From: Brad Brisbane <bab@mjnealaia.com>
Sent: Tuesday, January 20, 2015 10:42 AM
To: Kaycee Hathaway
Cc: 'Leif Langlois'; Mark Neal
Subject: 14469 Grow Bros response to Jan 12 letter from Kaycee @ Kittitas Co
Attachments: 2015-01-09 SEPA letter response.pdf; mfp@mjnealaia.com_20150120_115155.pdf

January 20, 2015

Re: Grow Bros SEPA SE-14-00011

RE: Grow Bros SEPA, SE-14-00011

# GrowBros Landscape Plan

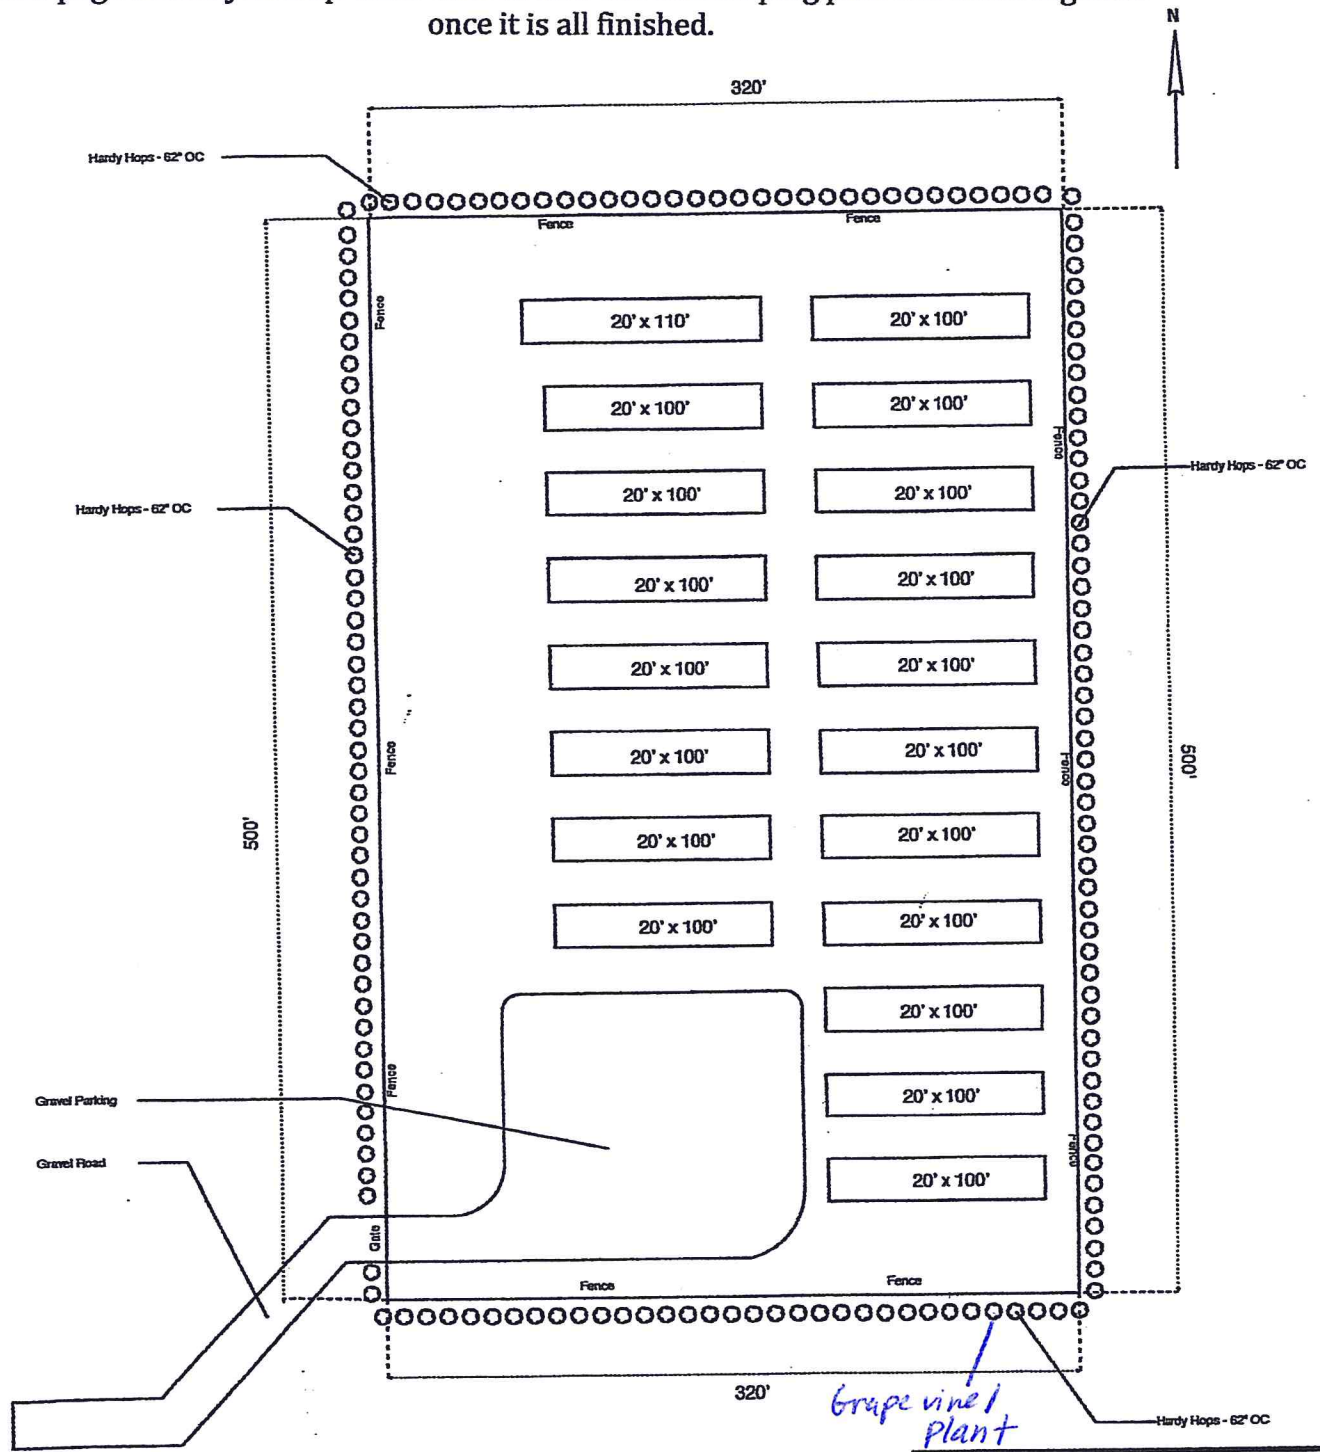
3. Clarification on question B. Environmental Health Section 4. Sub section d. Proposed landscaping, use of native plants, or other measures to preserve or enhance vegetation on the site, if any: *Hops planted at fence perimeter, 62 inches on center for sight obscuring.* In regards to this question is the landscaping plan turned in to CDS on November 21, 2014, see attached documents, for BP-14-00772, fence permit stating that there will be alternating hops and grape vines/plants totaling 166 plants, apply to this question?

In regards to your clarification question #3 in your letter dated January 12, 2015 pertaining to SEPA SE-14-00011 question B, Environment Health Section 4, Sub section d. please use the landscape plan turned into the CDS on November 21, 2014. In the mentioned plan BP-14-00772 please adopt the included fence permit plan stating that there will be alternating hops and grapes vices/plants totaling 166 plants and apply and use this for clarification of questions #3.
